Our Ref: P26176-FT-EGN-XX-RP-EN-0001

Re: Review of Further Information Submitted (EIAR Chapter 7) - LRD26A/0051/WEB - St Teresas LRD

Review of Further Information relating to Chapter 7 Land, Soils, Geology and Hydrogeology

Figure 7.14 - Hydrogeological cross section A-A'

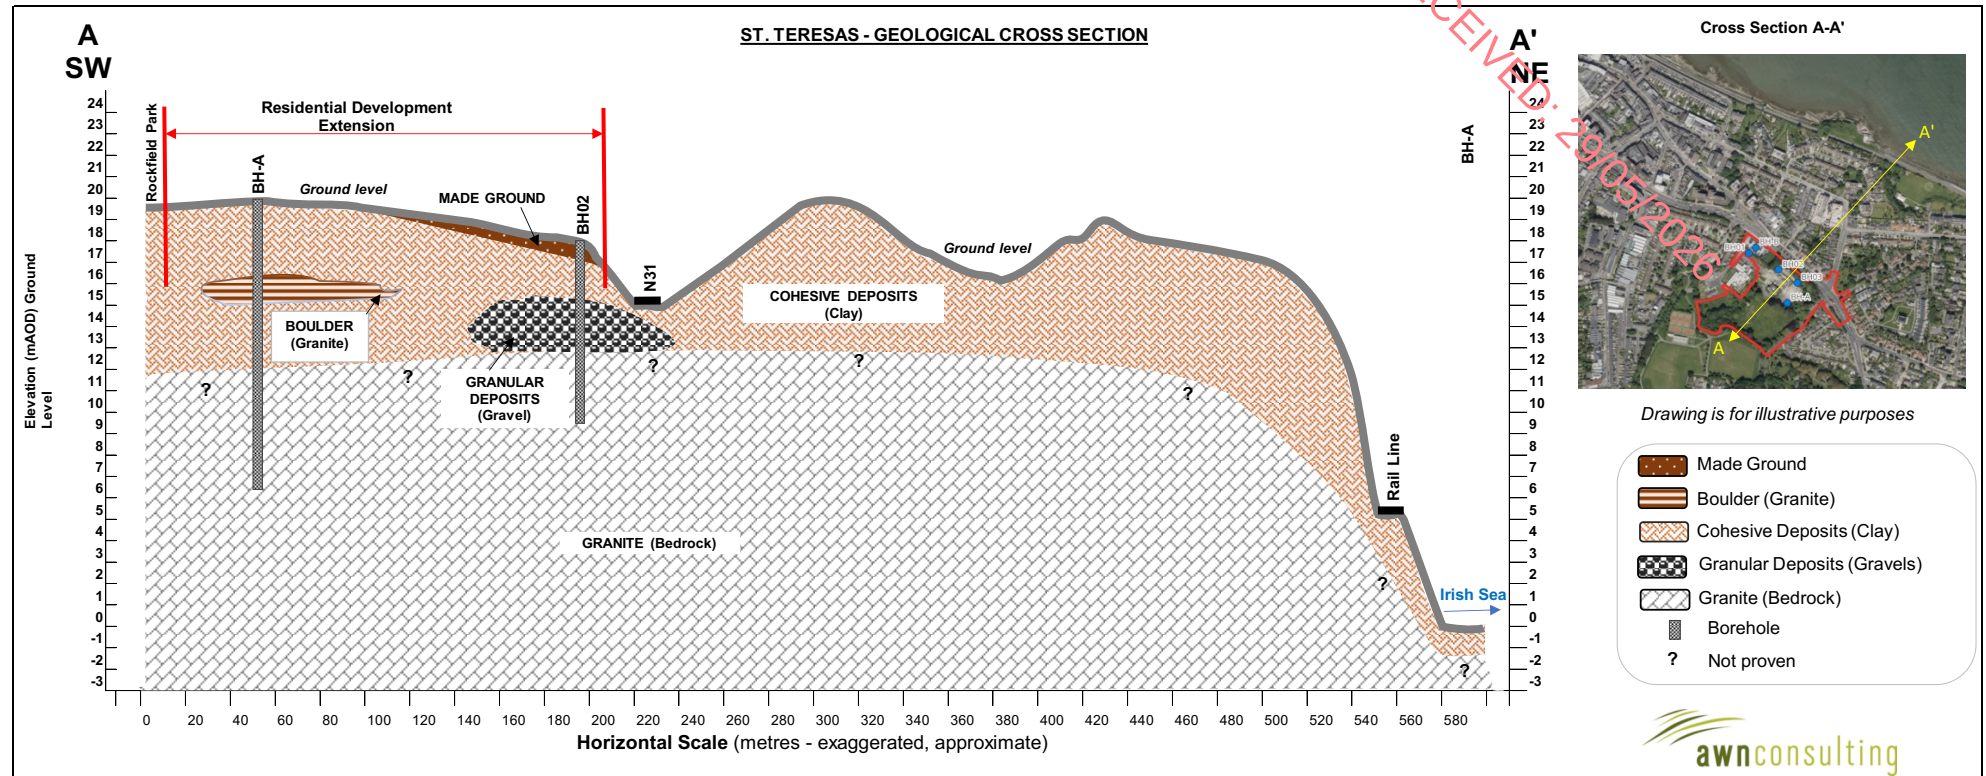
Review of Item		Response Summary	Review of Information Provided
Land, Soils, Geology and Hydrogeology			
2.	Chapter 7: Land, Soils, Geology, and Hydrogeology does not assess the potential impact to bedrock from the proposed piled foundations. The CEMP states that piling/coring through rock may be required to allow excavation of the basements in the strata above the rock in accordance with the proposed design. The potential impact to land, soils, geology and hydrogeology from the proposed piled foundations should be assessed and associated mitigation measures should be specified, if required.	The applicant has submitted a revised EIAR Chapter 7 and revised EIAR Non-Technical Summary. Chapter 7 of the EIAR has been updated to address the potential impact to bedrock from the proposed piled foundations. Section 7.5.2 has been updated to specifically consider the potential impacts of the proposed development on bedrock, in addition to land, soils and geology. It is stated that the proposed piled foundations have the potential to interact with the underlying geological strata, including bedrock, where piling, coring or excavation through rock is required. Based on the available geotechnical information, significant impacts to bedrock from the proposed piled foundations are not anticipated. The proposed excavation for Block B is estimated to extend to approximately 8.0 m	The response is considered satisfactory. The revised Chapter 7 is considered robust and accurate, with appropriate mitigation measures specified. It is recommended that Planning Conditions are included to agree the details of all piling and foundation construction works with the Planning Authority prior to construction of the building foundations and to ensure the implementation of the specified mitigation measures. It is noted that the revised Non-Technical Summary (NTS) Chapter 7 does not include details of the revised piling assessment; however, given that piling effects are predicted to neutral, short-term and imperceptible, with

Review of Item	Response Summary	Review of Information Provided
Land, Soils, Geology and Hydrogeology		
	BGL and may penetrate weathered granite between approximately 6.8 m BGL and the base of the excavation. The excavation for Block A may not encounter bedrock, as bedrock was not recorded until approximately 8.0 m BGL in this area. Any potential interaction with bedrock is therefore expected to be limited and localised. There is no change to the potential impacts during the construction phase on land, soils geology. In relation to bedrock, potential impacts associated with the proposed piled foundations are negative, imperceptible and short term, in the absence of mitigation. Mitigation measures are outlined in Section 7.8.2 of the revised EIAR chapter. It is stated that the potential impacts will be effectively managed through the CEMP and detailed method statements, including appropriate piling techniques, vibration control, groundwater management, and off-site reuse/disposal of materials, alongside engineering verification of founding conditions. With mitigation in place, residual impacts are predicted to be neutral, short-term and imperceptible, with a negligible magnitude, in accordance with TII criteria.	a negligible magnitude, this is not considered to materially affect the outcome of the NTS. The revised mitigation measures outlined in the revised Chapter 7 do not align with the CEMP prepared for the proposed development. It is recommended that a Planning Condition is included to require a final CEMP to be agreed with the planning authority, prior to commencement of development.

- Prior to the commencement of any works associated with the development hereby permitted, the developer shall submit an updated, detailed Construction Environmental Management Plan (CEMP) for the written agreement of the planning authority. The CEMP shall incorporate as a minimum detail for the following: surface water run-off from the site, groundwater management, management of noise and vibration, and all environmental management measures to be implemented during construction. A dedicated process for recording all complaints and mitigation measures implemented shall be defined in the CEMP. A record of daily checks that the construction works are being undertaken in accordance with the CEMP shall be kept at the construction site office for inspection by the planning authority. The agreed CEMP shall be implemented in full in the carrying out of the development.

- Prior to construction of the building foundations, details of all piling and foundation construction works shall be submitted to and agreed in writing with the Planning Authority, including the results of an inspection of the founding strata by a suitably qualified engineer. All points of detail relating to these works shall be agreed in advance of the works, including the piling method, measures to control noise and vibration, groundwater protection measures, specific procedures for dealing with any groundwater impacts, protection of nearby structures and underground services, and monitoring arrangements. All works shall be carried out in accordance with the agreed details.

REASON: In the interest of environmental protection, residential amenities, and public health and safety.
